Arun District Council
Arun Civic Centre
Maltravers Road
Littlehampton
West Sussex BN17 5LF
Planning & Building Control General Enquiries
Tel: (01903) 737756 Fax: (01903) 730442
Dx: 57406 Littlehampton
Minicom: 01903 732765
e-mail: planning@arun.gov.uk
website: www.arun.gov.uk/planning

Application No: R/102/20/PL
Site Address: Land north of Springfield house Cross Road Rustington BN16 2ST
Description of works: 1 No. detached 5-bedroom house with attached single storey double garage & carport.

Thank you for your internet representation made on 23rd July 2020 which has been recorded as an objection with the comments as follows:

Cross Road Angmering - Mechanical Services Schematic

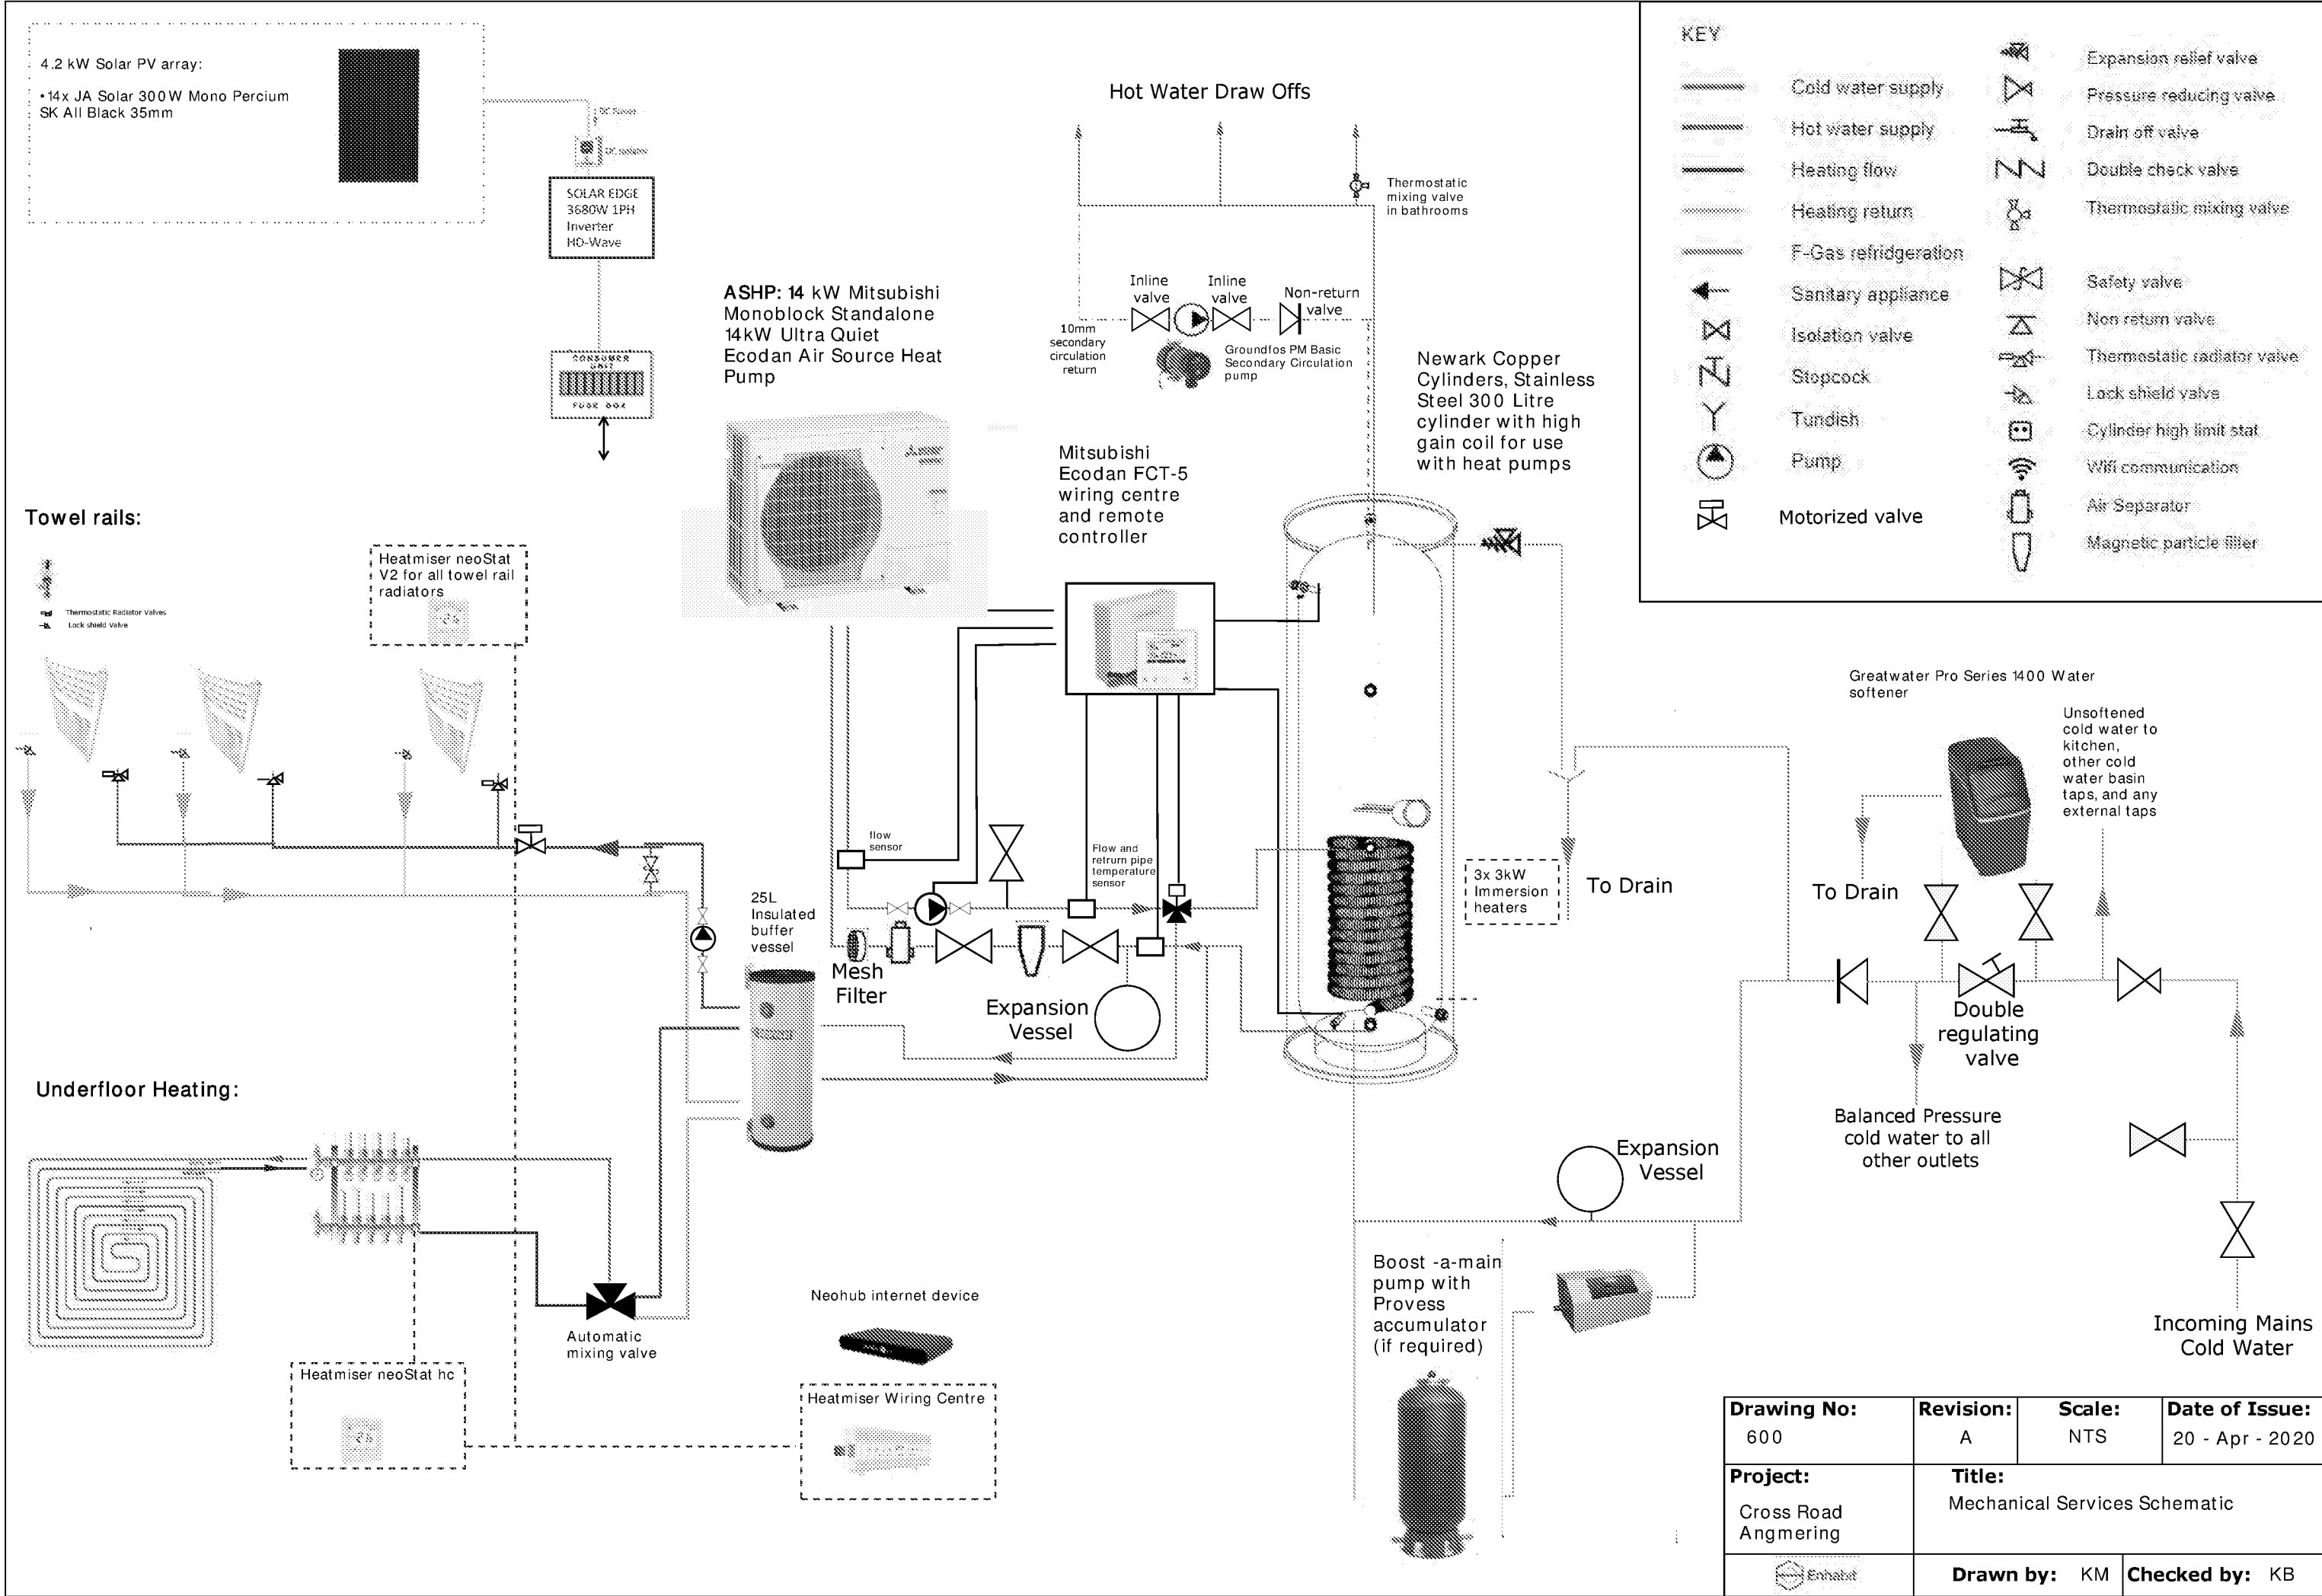
1. No notice has been put up to notify residents of the planning application.
2. I would object to the feature lighting in the external courtyard due to evidence that bats are in the area, the effects on the dark sky at night and affecting adjacent properties with light pollution.
3. The air source heat pump needs to be housed in a way that this will not adversely affect the adjoining properties with noise pollution.
4. There would be a concern that the basement structure would undermine the root structures of the Macrocarpa trees to the west making them unstable in high winds, this should be properly assessed.
